**MAJOR PROJECT ASSESSEMENT:
University of Technology Sydney
Peter Johnson Building -
Redevelopment for student housing
Major Project Application MP 09_0021**

Director-General's
Environmental Assessment Report
Section 75I of the *Environmental Planning and
Assessment Act, 1979*

December 2009

ULTIMO PEDESTRIAN NETWORK

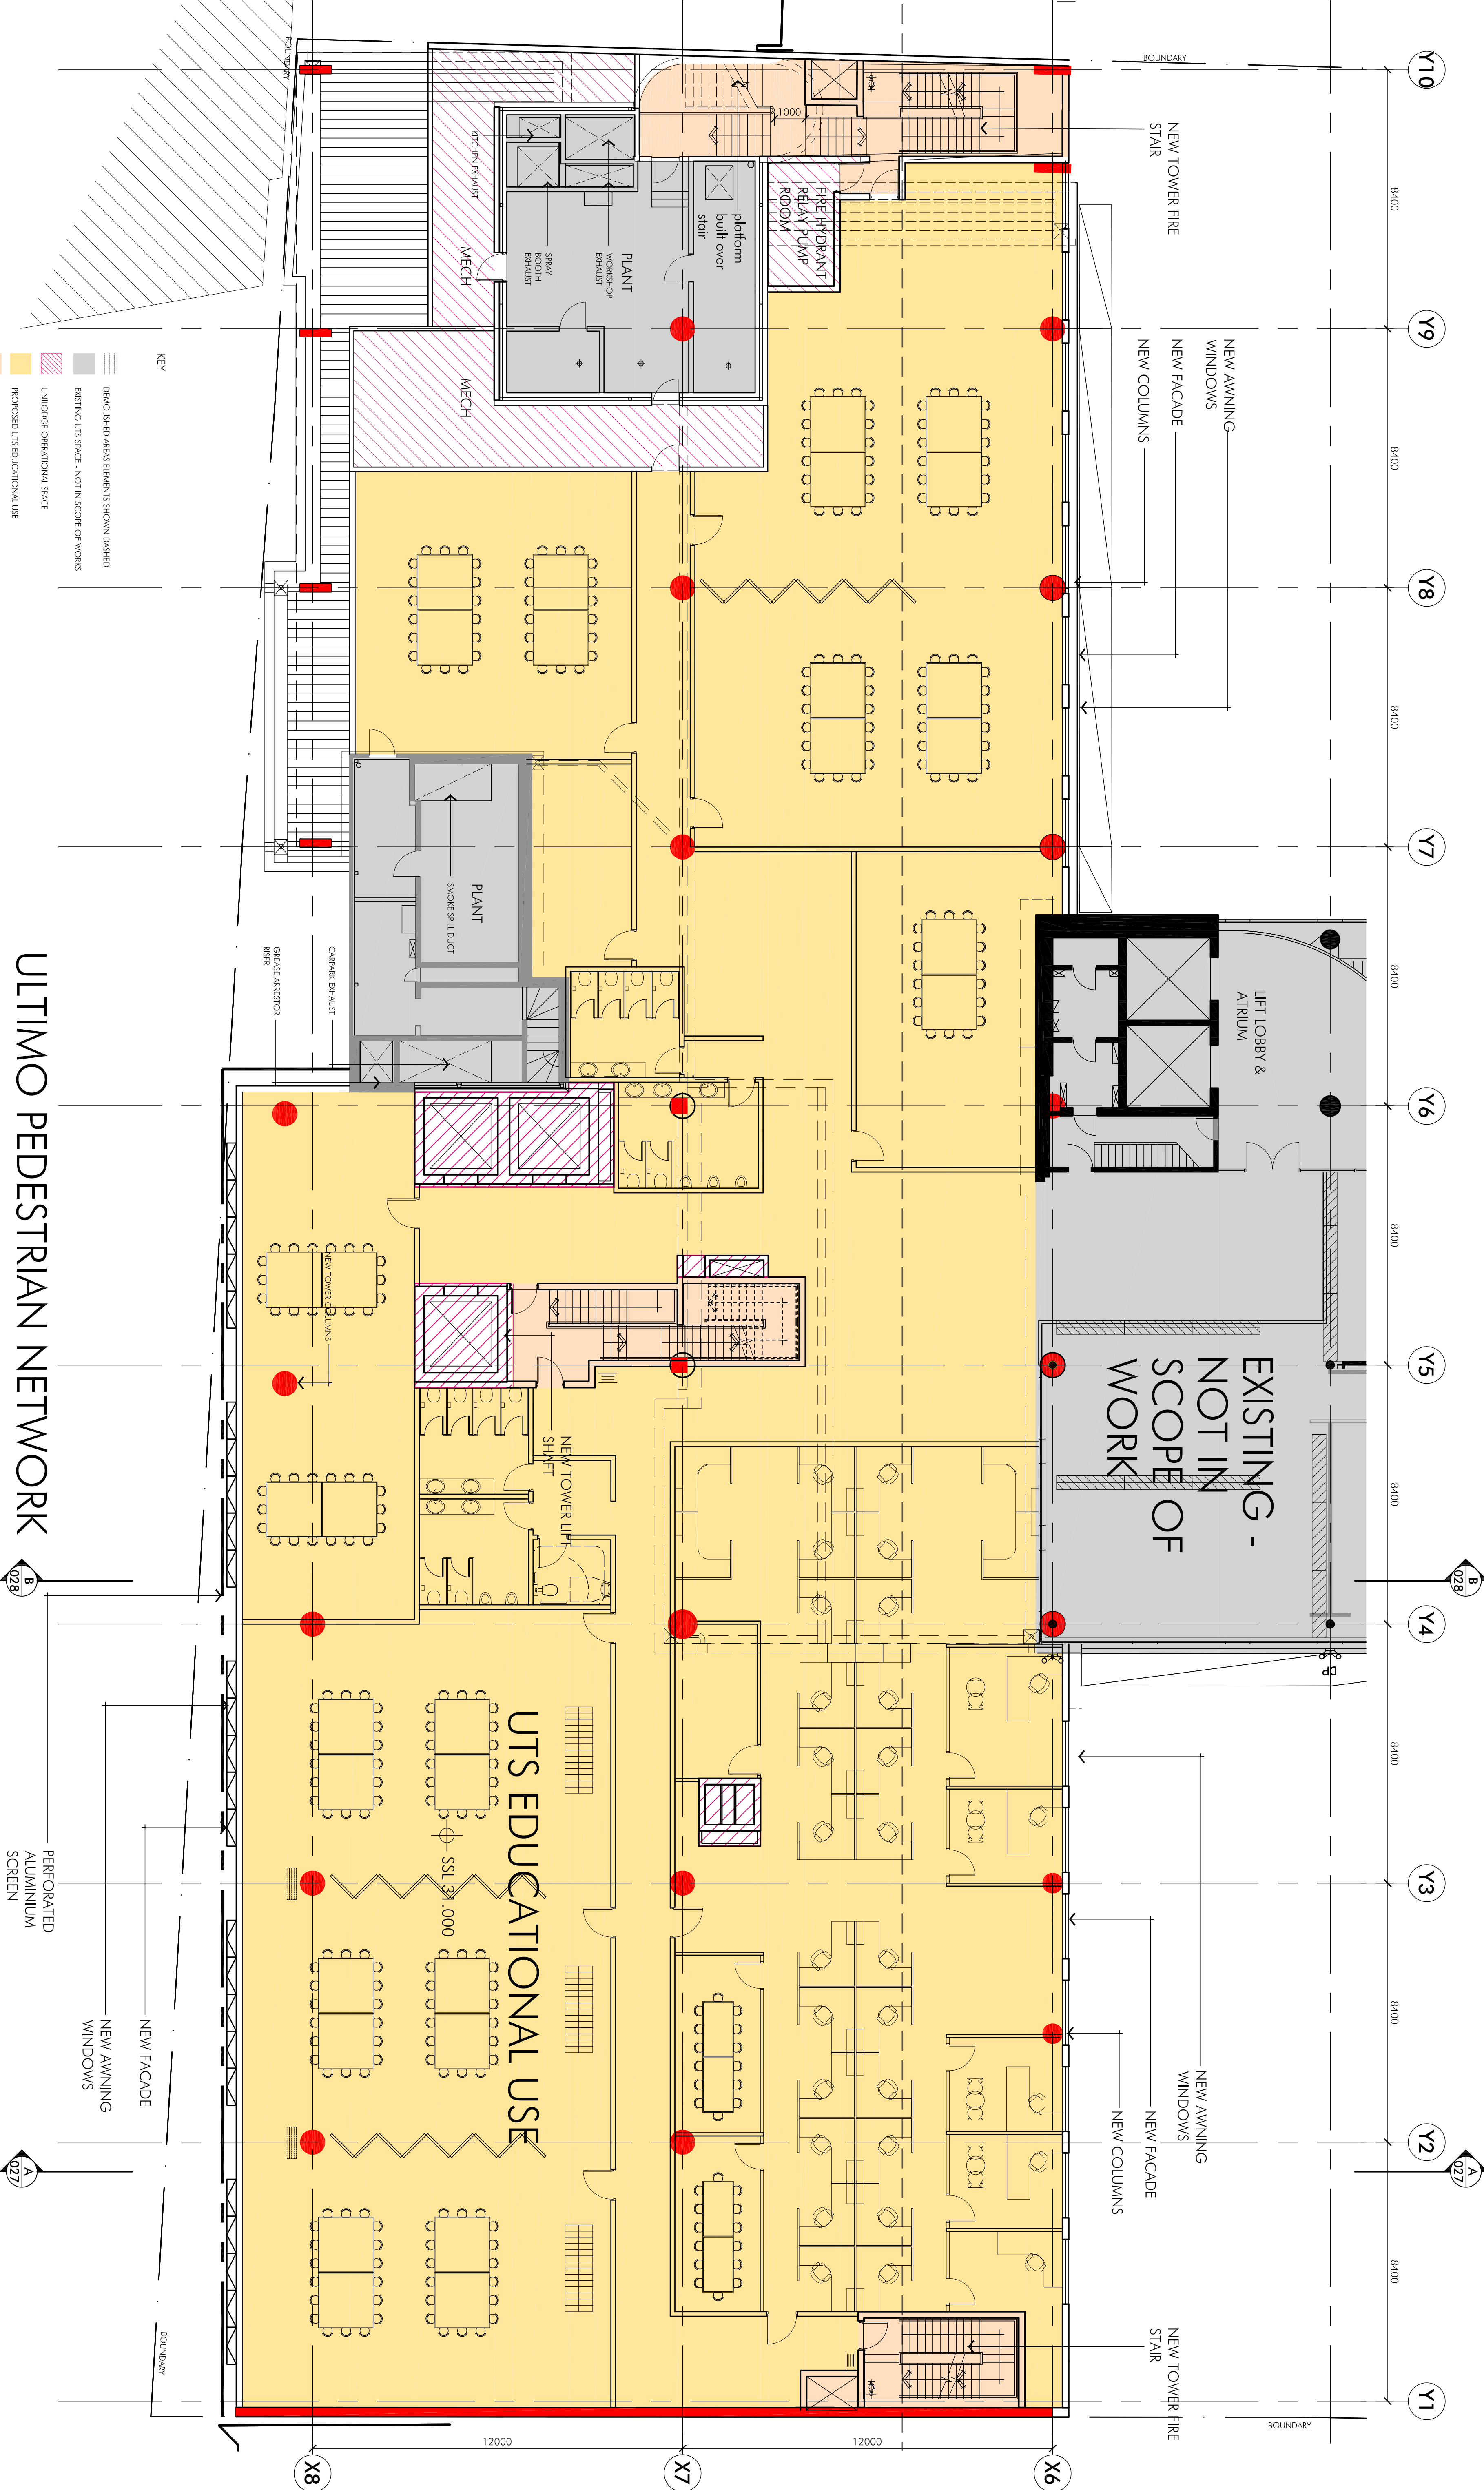
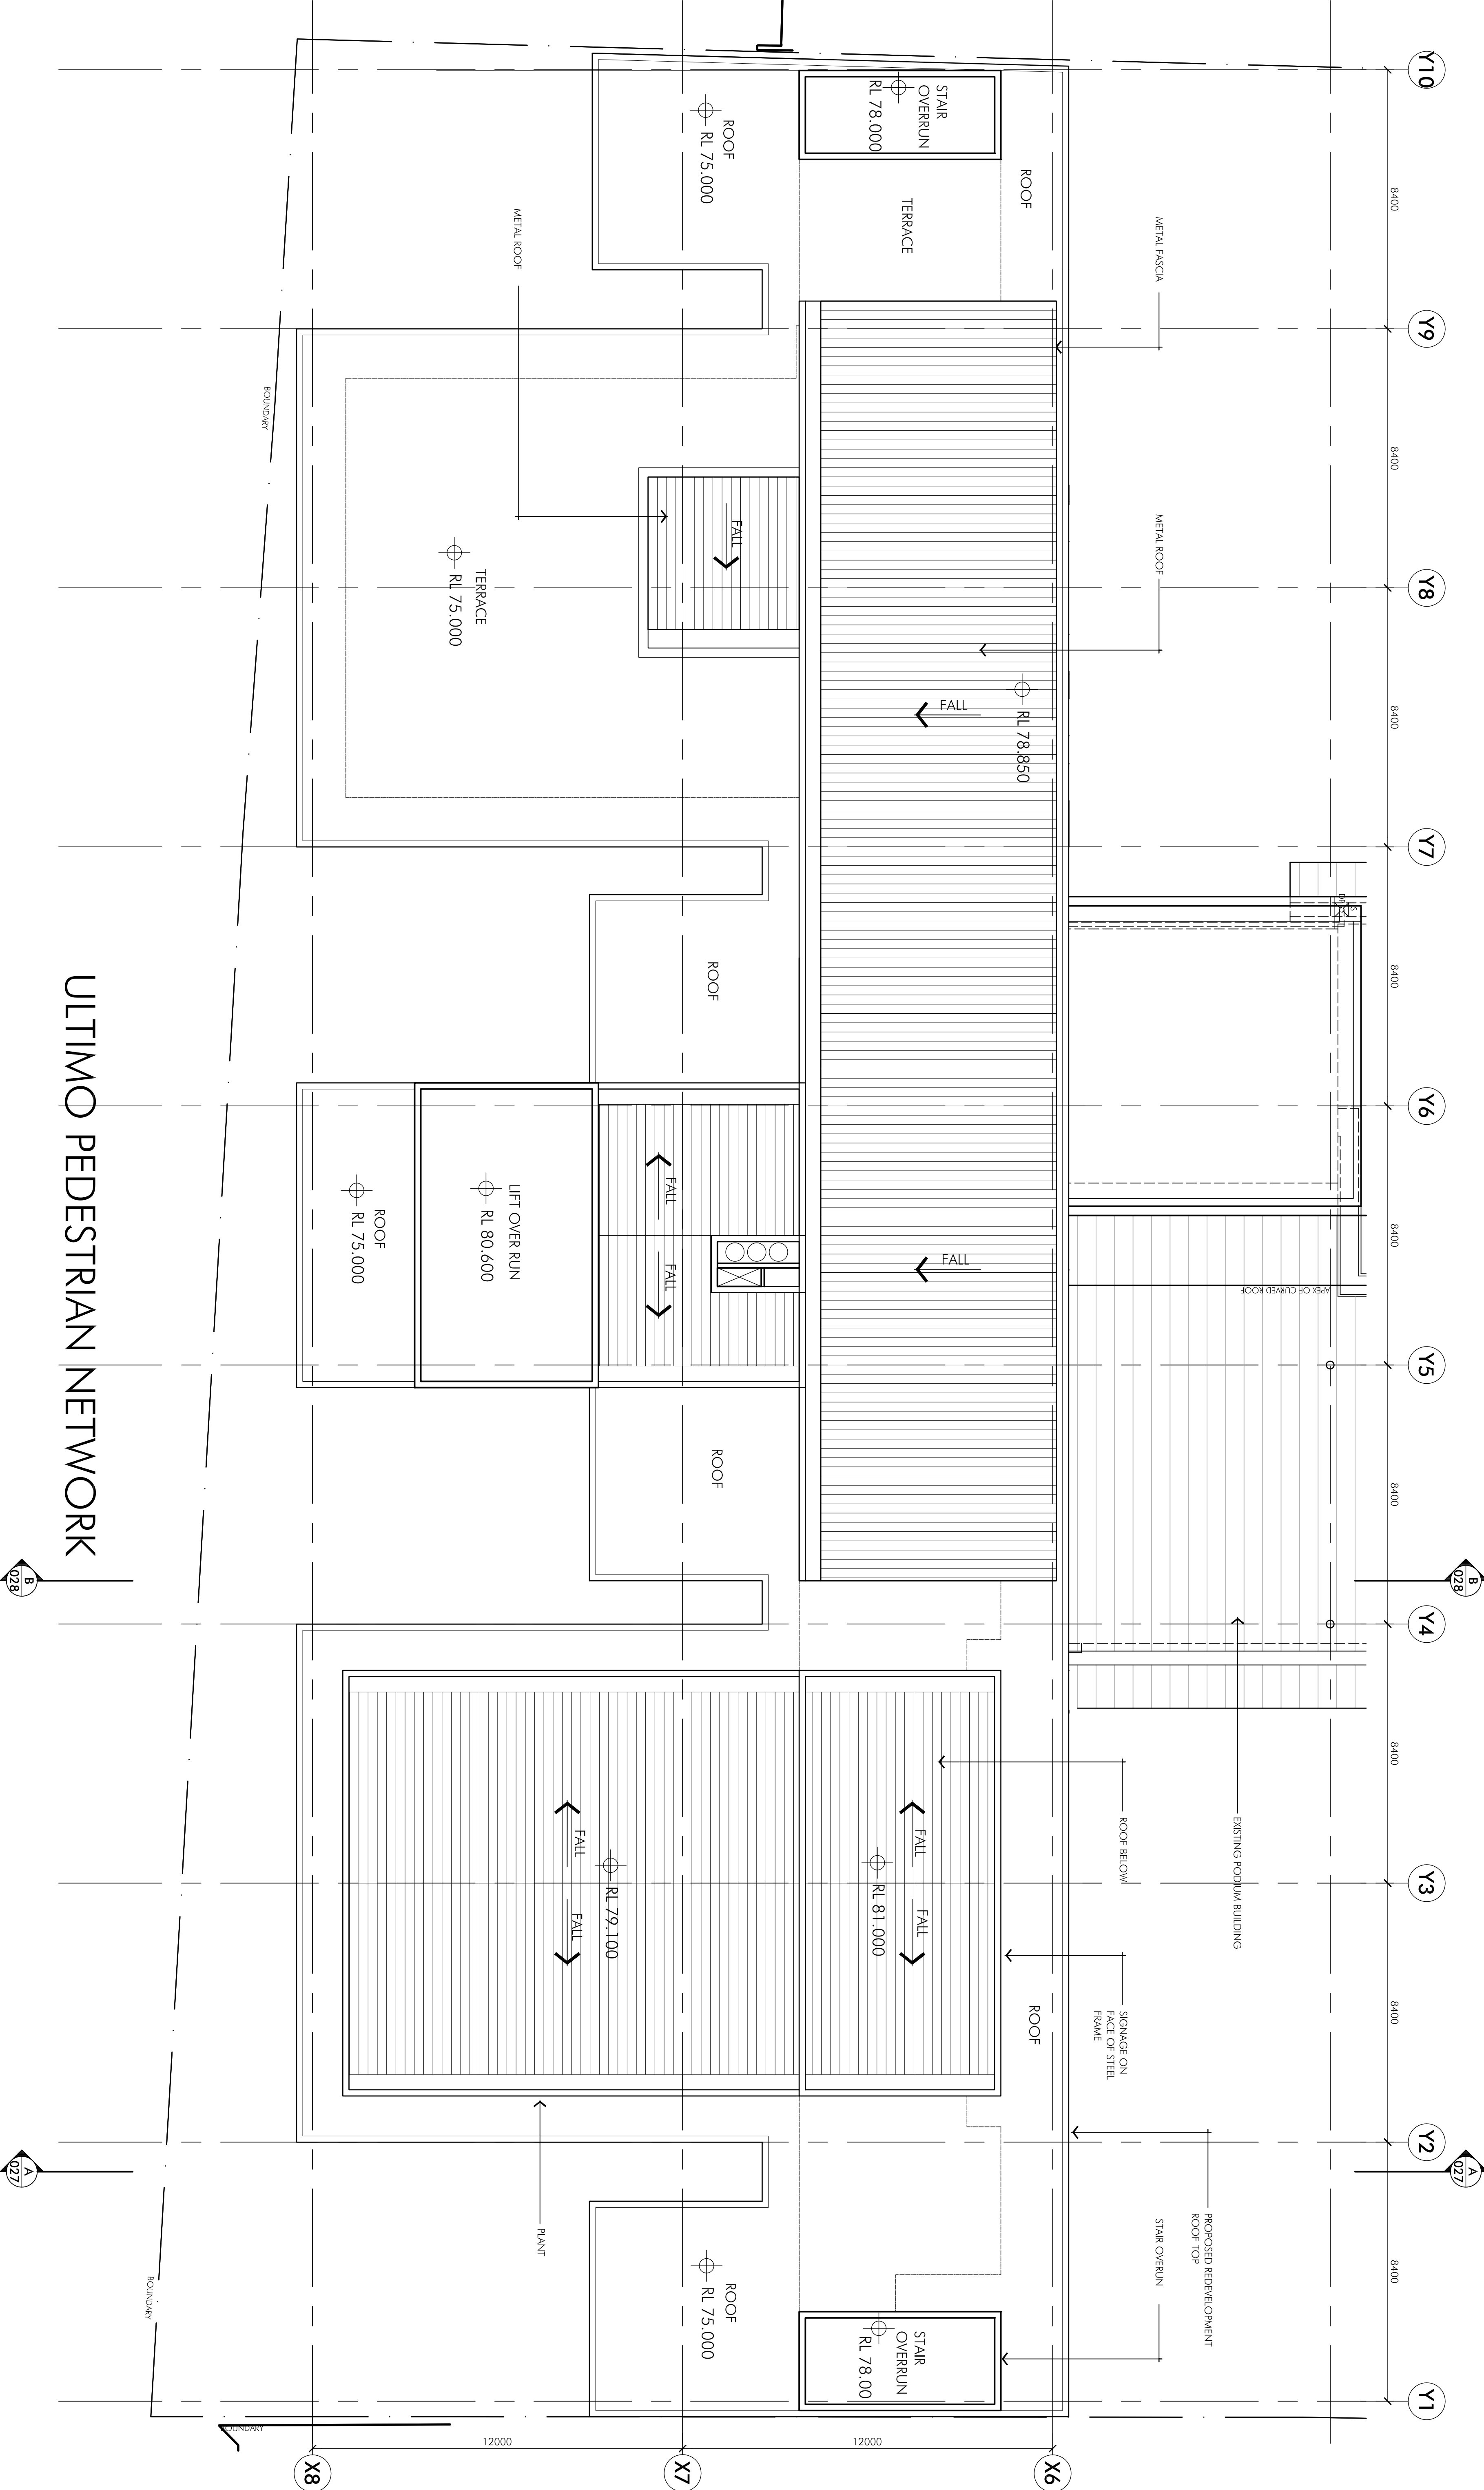
The Council requested that the podium on the UPN frontage should match the height of the indented podium of the ABC building. However, the Department notes that the podium element is existing and therefore opportunities for changes to this structure are limited. The purpose of a podium is to assist in creating a clear base for a building along street frontages, which will still be the case for this development. The height of the podium is similar to the ABC building podium, and a substantial redesign to match the ABC building is not warranted, especially as the podium level is not consistently applied to other buildings fronting the UPN.

The City was of the opinion that the redevelopment creates an opportunity to remove the bridge, which is considered to be of poor visual quality.

UTS maintains that the UPN bridge and stair/escalator provides a publicly accessible path within the university with direct connection to public transport and should be retained. Public access from the UPN to Level 4 could be internalised (where it is only proposed for student housing residents) although modifications to the internal design of the building would be required. The Department considers that the issue will be best addressed as part of the UTS Broadway Concept Plan, which covers public domain improvements and pedestrian paths of travel across the site.

HARRIS STREET ELEVATION

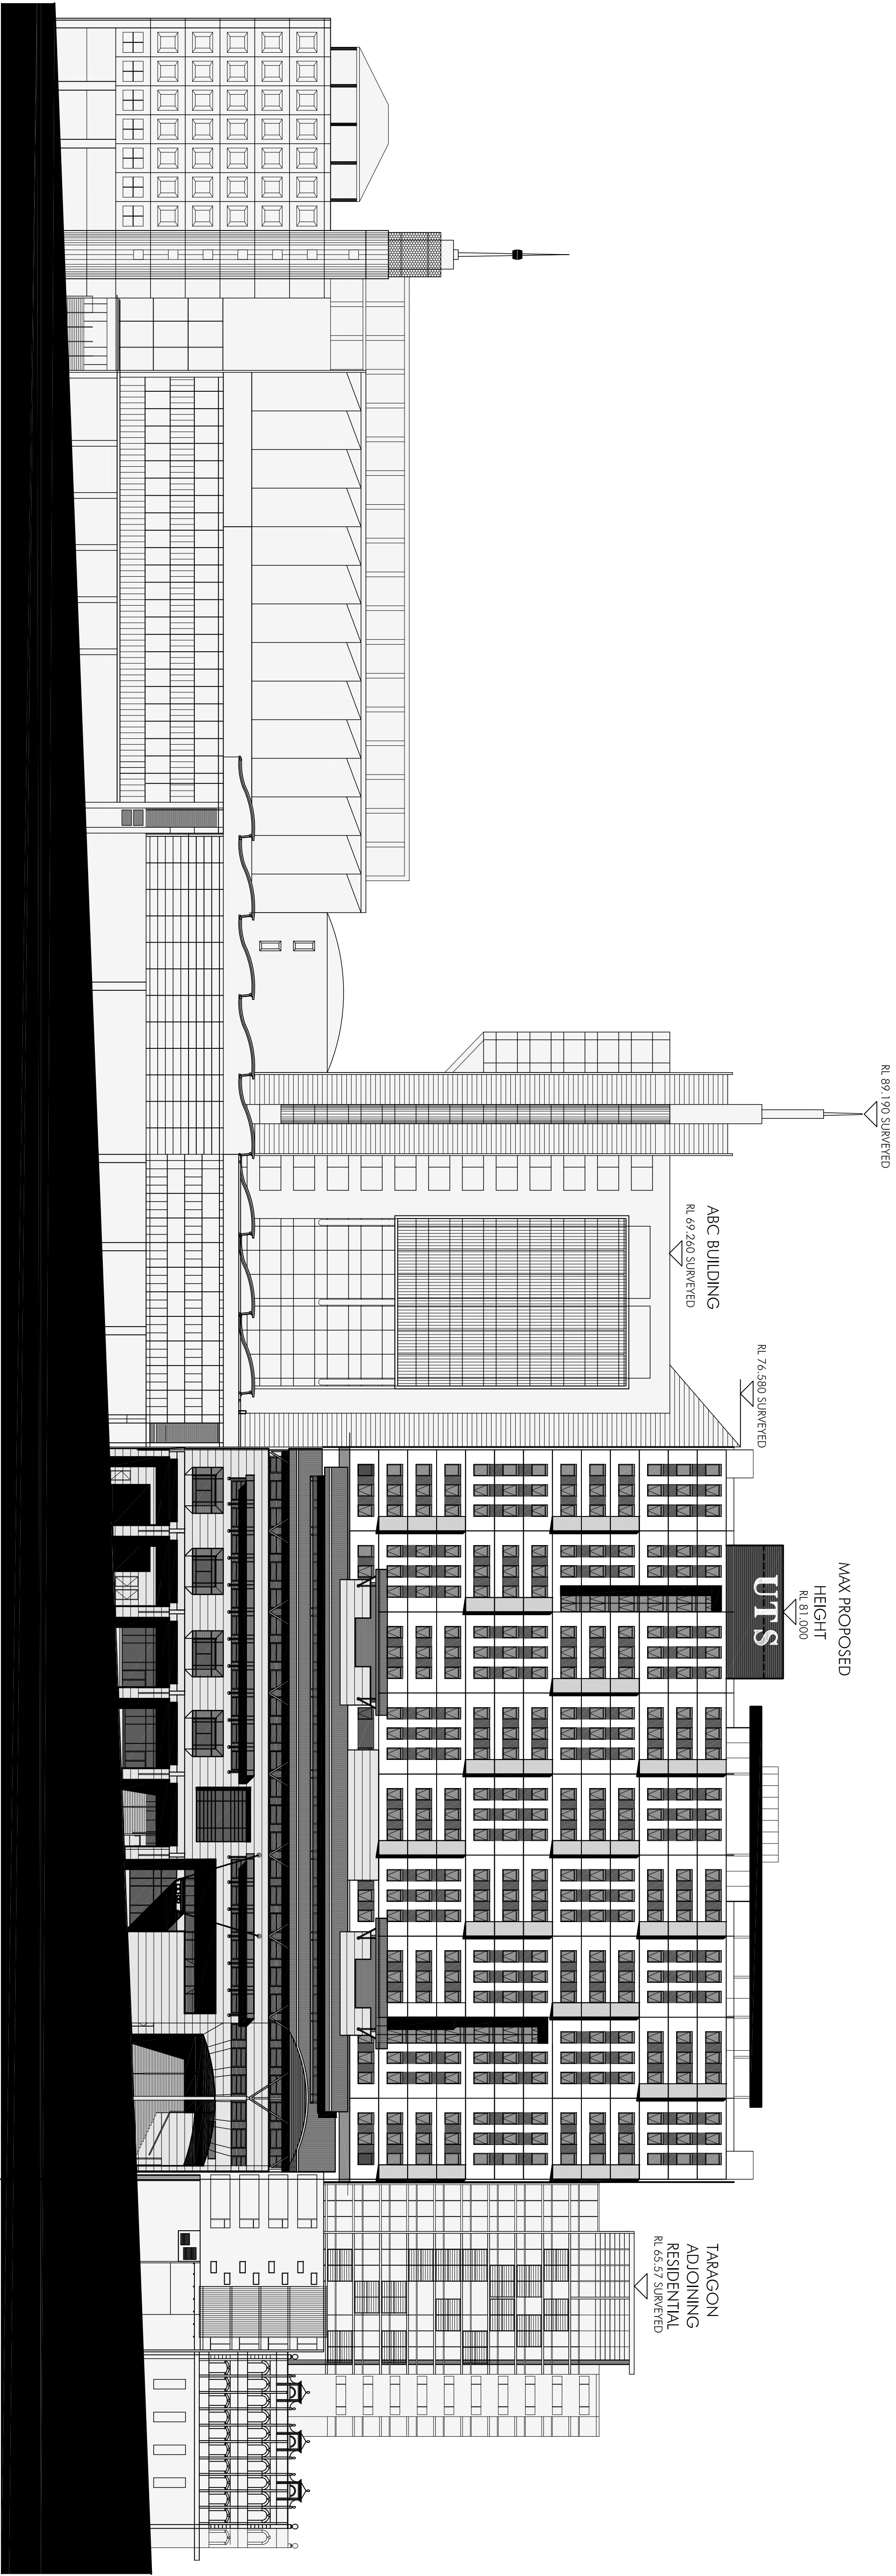
The City of Sydney's main concerns with the proposal related to the massing resulting from the façade detailing and materials, including the colour scheme proposed and lack of articulation.

The proponent amended the design of the tower element in the PPR to address Council's concerns. The changes include:

- Modifications to articulation on the Harris Street frontage, to modulate the massing of the building into three vertical sections;
- Use of varied colour treatments and window sizes;
- Changes to the floor plan to accommodate the external changes.

The City of Sydney advised the Department that it is satisfied with the revised design of the Harris Street façade.
